**RE: Slim Chicken
8240 Montgomery Blvd NE
Grading and Drainage Plans
Engineer's Stamp Date: 04/26/21
Hydrology File: G19D004E**

Based upon the information provided in your resubmittal received 04/26/2022, the Grading & Drainage Plan is **not** approved for Building Permit and for action by the DRB on Site Plan for Building Permit. The following comments need to be addressed for approval of the above referenced project:

SLIM CHICKEN
8240 MONTGOMERY BLVD NE
GRADING AND DRAINAGE PLAN

EROSION CONTROL NOTES

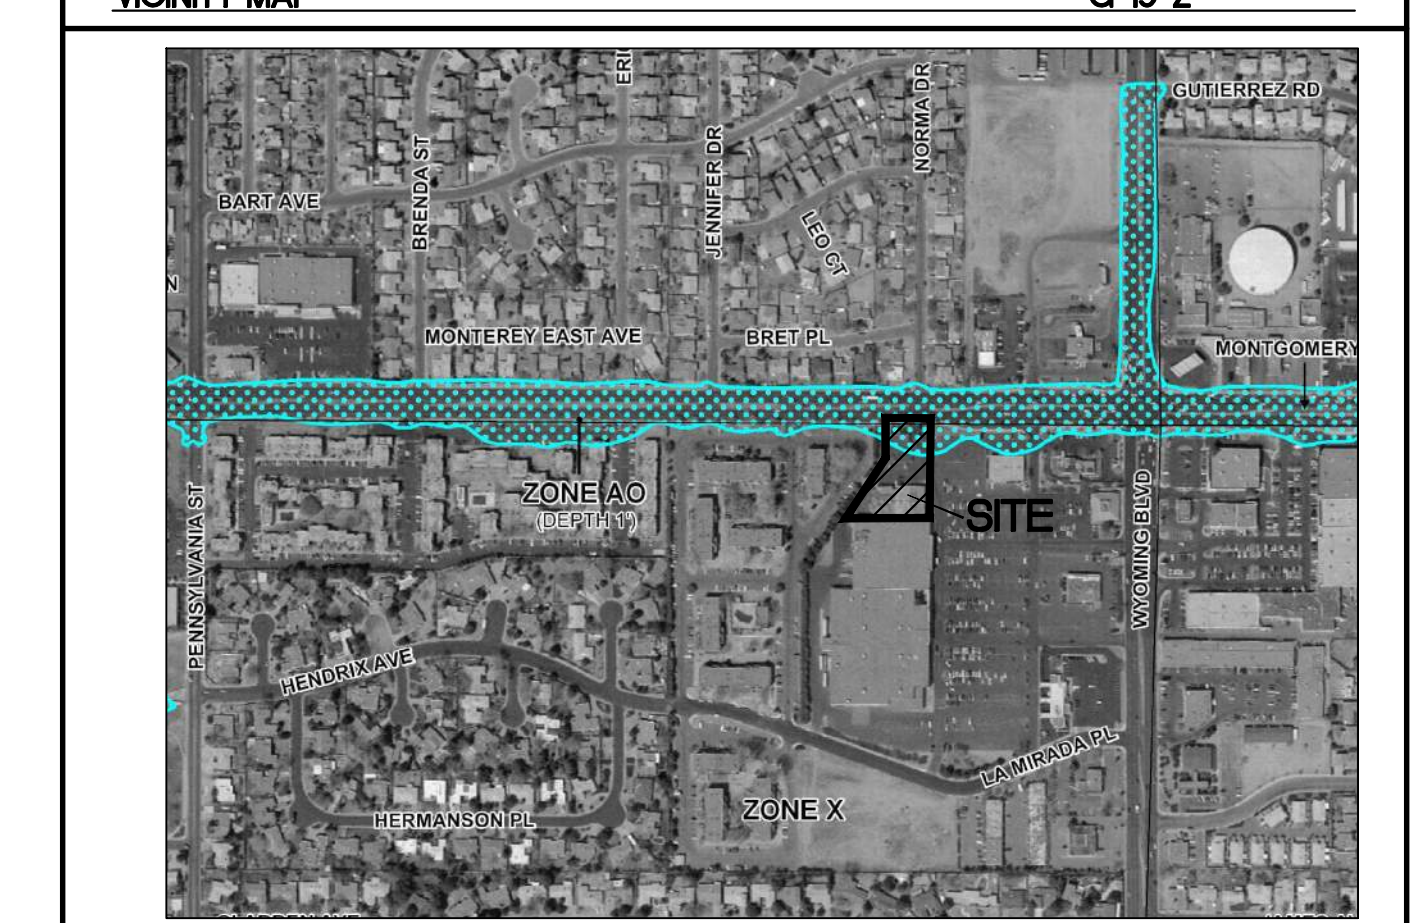
1. Please cleanup overlapping text.

2. The entire Tract A needs to follow the approved overall development drainage management plan. See the wording below from that plan.

COMMERCIAL BASIN "A" AND "B" WILL DRAIN SOUTH TO A PROPOSED DROP INLET LOCATED JUST NORTH OF WYMONT CIRCLE. THOSE FLOWS WILL BE CONVEYED THROUGH STORM SEWER TO THE WATER QUALITY POND. BASIN "C" WILL DISCHARGE TO A PROPOSED DROP INLET AT THE ENTRANCE ON MONTGOMERY AND DRAIN VIA STORM SEWER TO THE DROP INLET THAT CAPTURES BASINS "A" & "B".
